Re: Permit # 05-0142, 126 Hope Ave. (390-A-011)

I have commenced the review of the plans for the above referenced new single family home. The following additional information is required:

BASEMENT PLAN

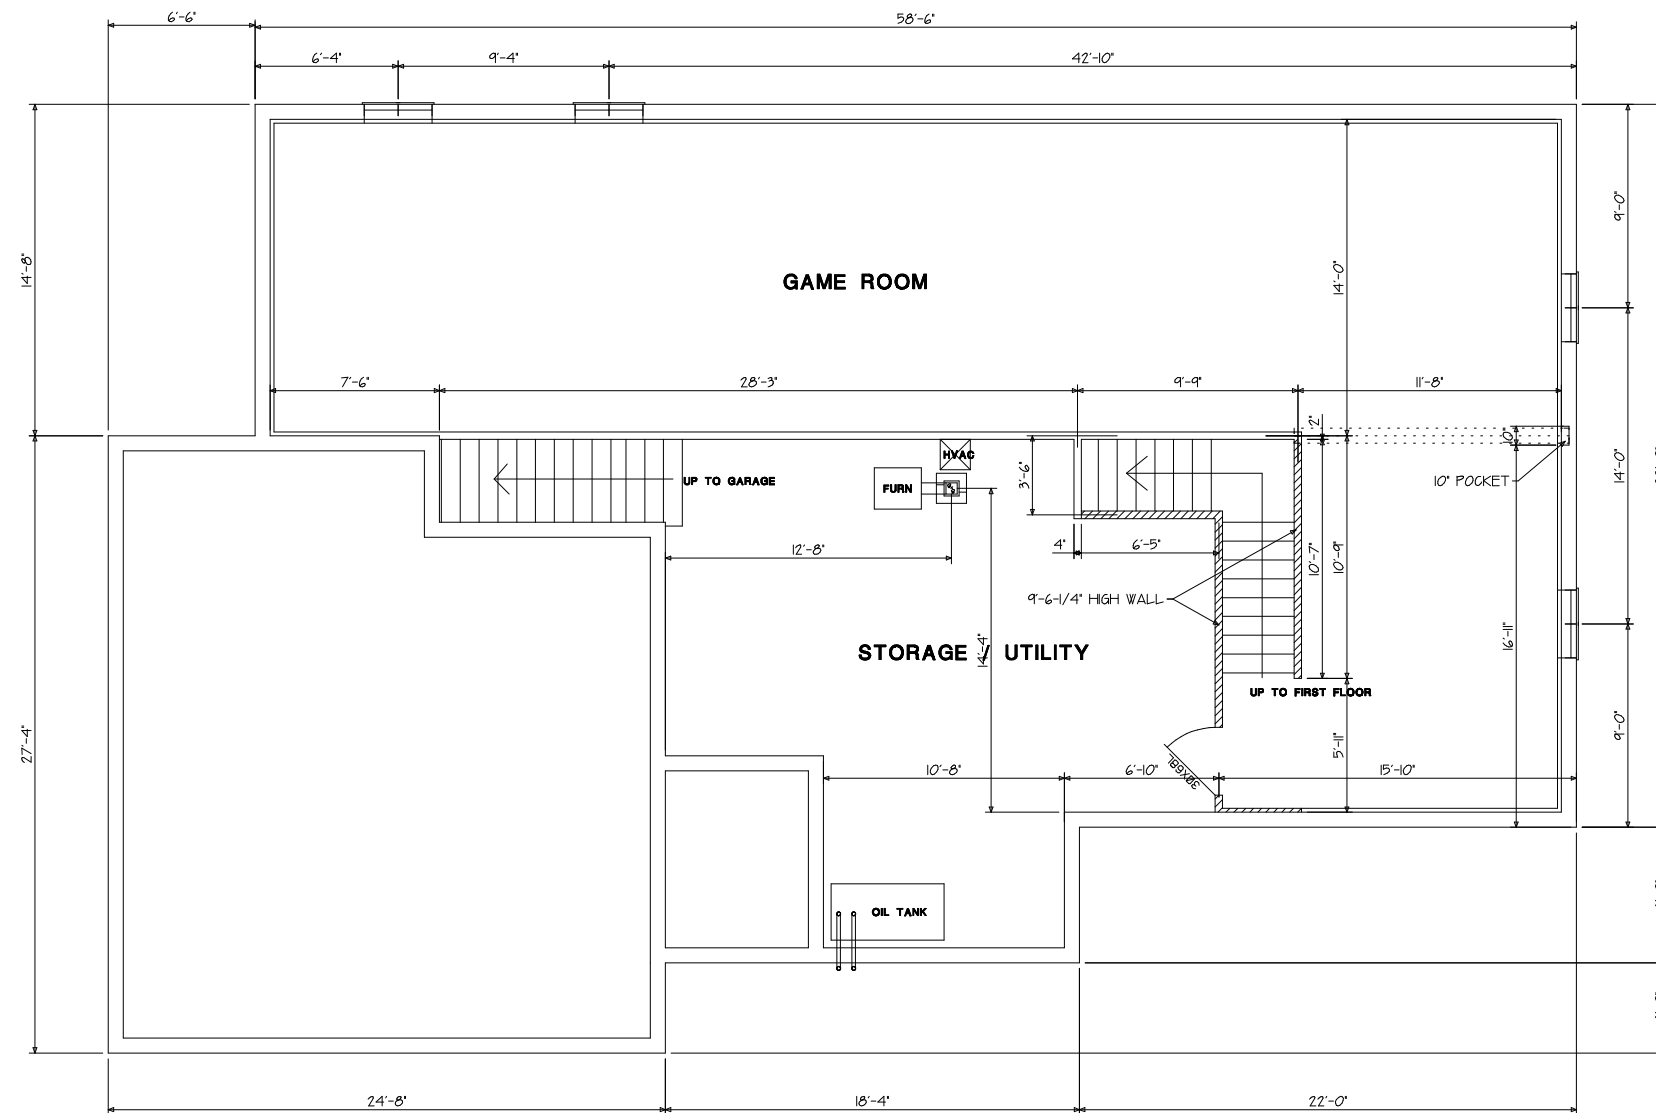
13. Show location and dimensions of attic scuttle.
14. Call out chimney clearances to combustibles & fire blocking.
15. Since the basement is showing habitable space in the game room, there needs to be a code compliant second means of egress from that space. The garage is not allowed unless there is protection to an exterior door.

### FOUNDATION PLAN

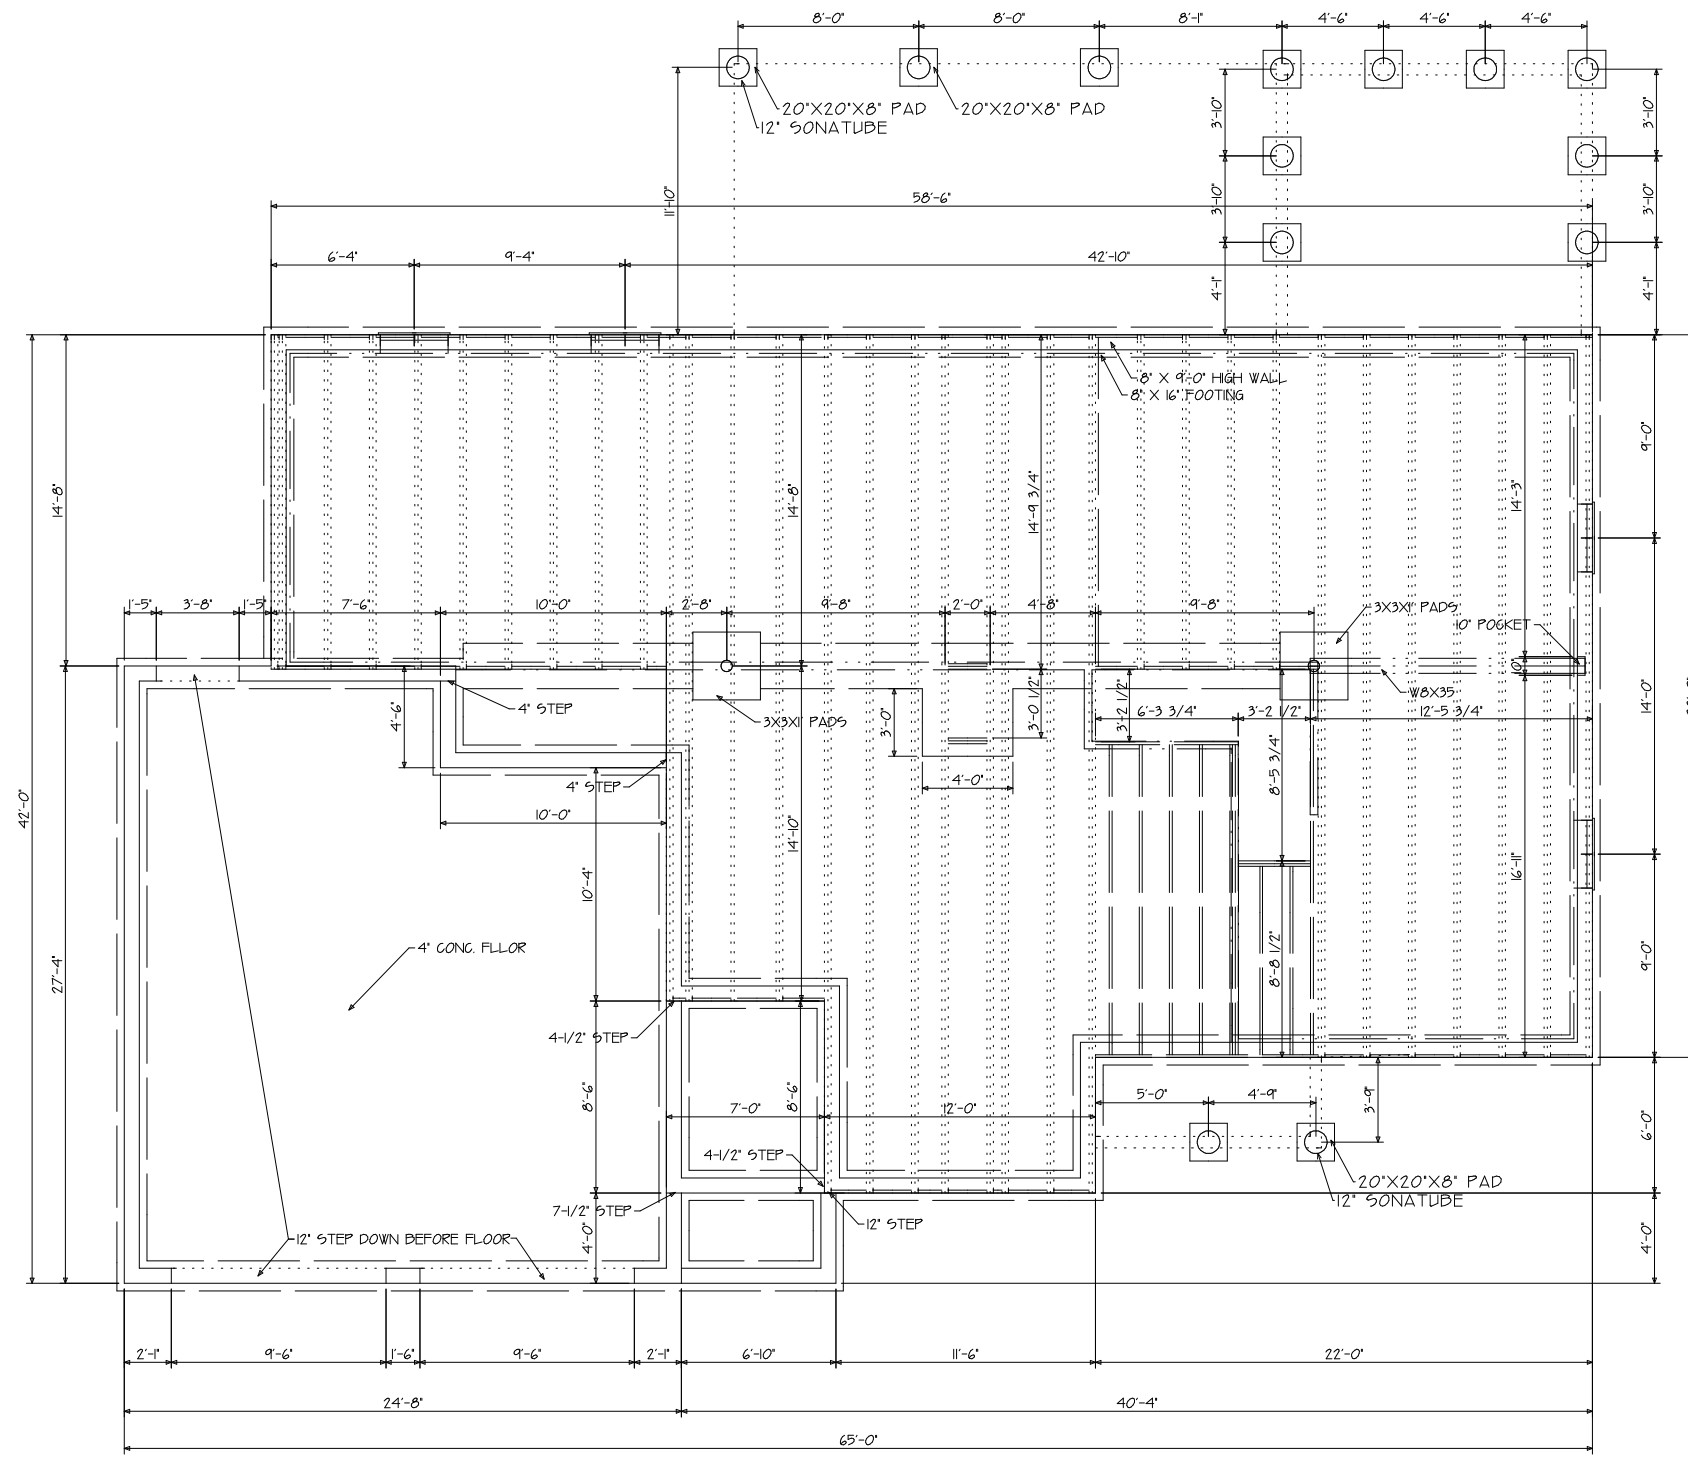
1. Footing dimension, foundation drainage, fabric & damp proofing not specified.
2. Foundation anchors bolts and sill plate not specified.
3. Lally columns not specified.

ROOF FRAMING PLAN

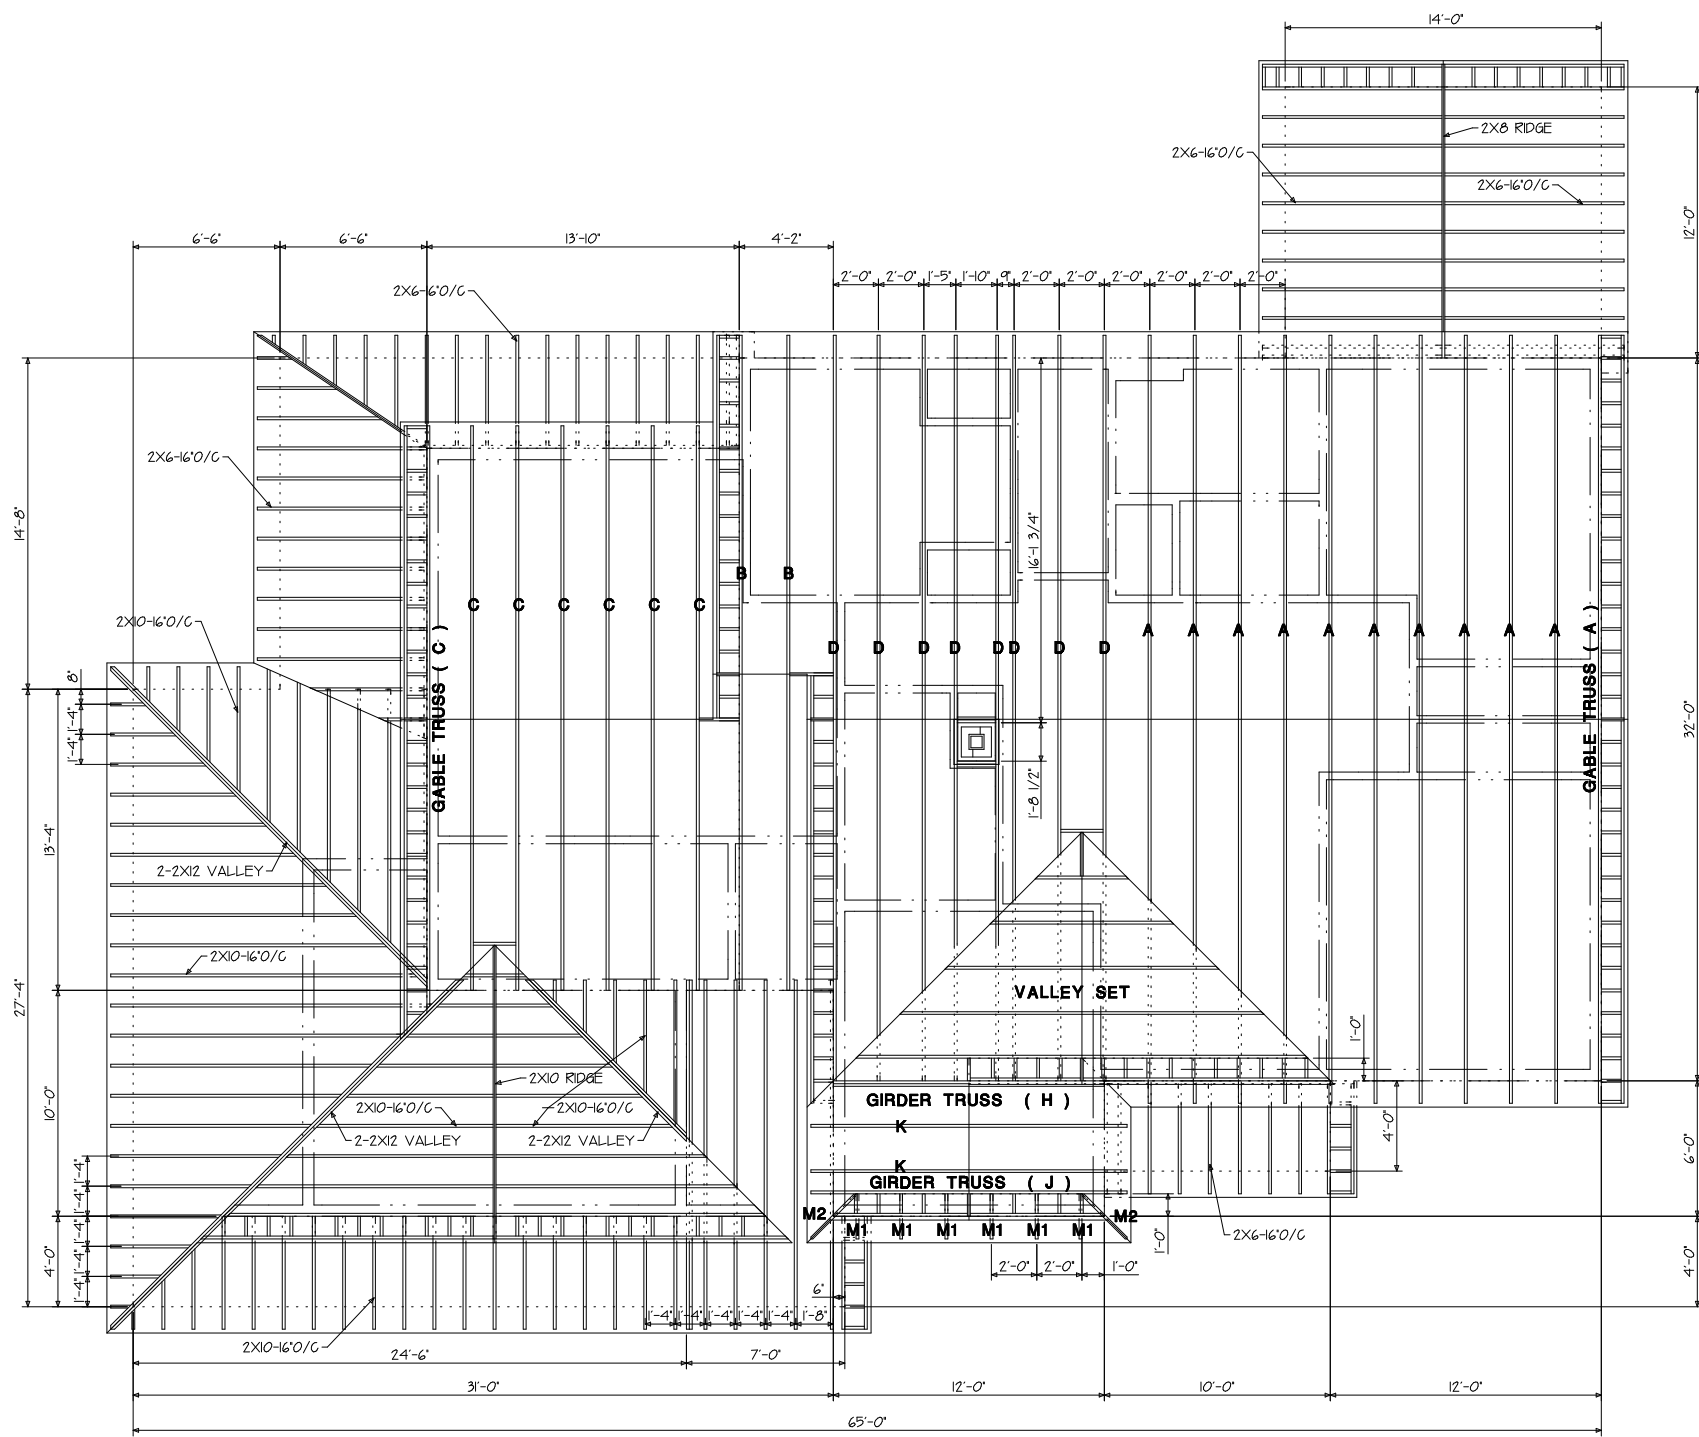
6. Call out the mudroom floor joists
7. Call out floor sheathing & correct 5/4" cdx on roof.
8. Call out the fastener schedule – using the 2003 IRC
9. Because there is some habitable space above the garage, call out the fire separation and opening protection

SECOND FLOOR PLAN
1443 SQ.FT.

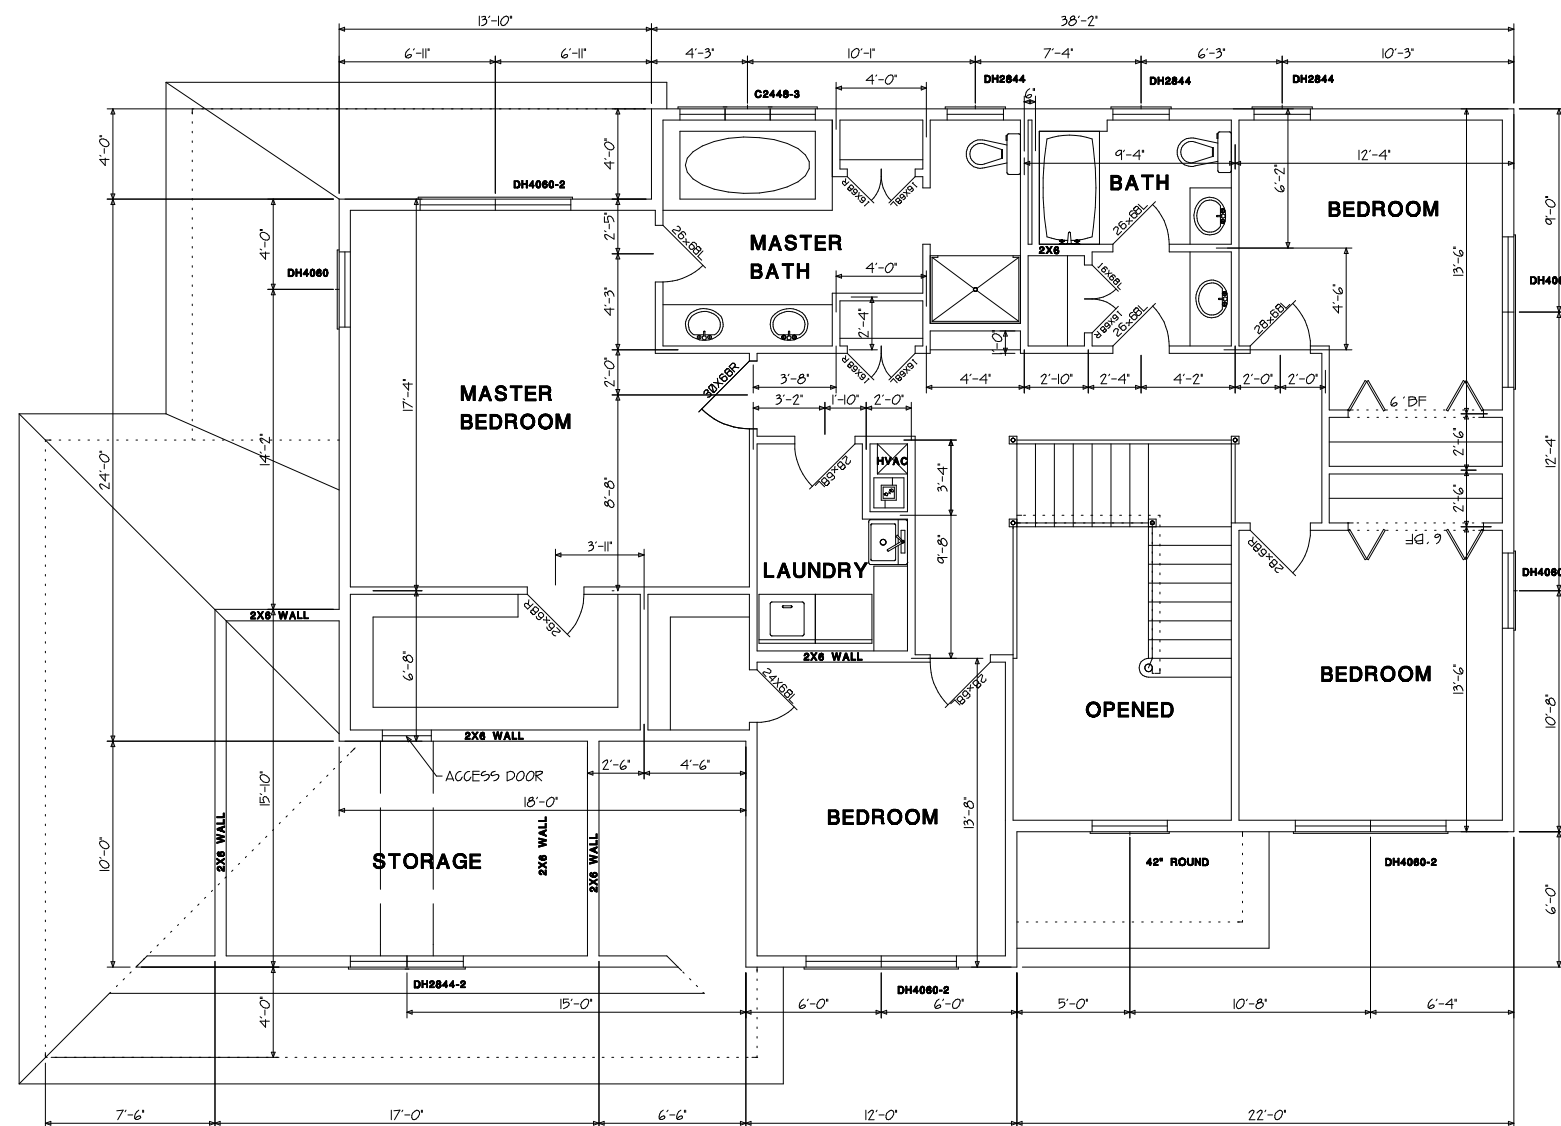
10. Call out the min. required egress for each bedroom
11. What type of roof **shingles** are being used?
12. Call out the safety glazing required in the master bath
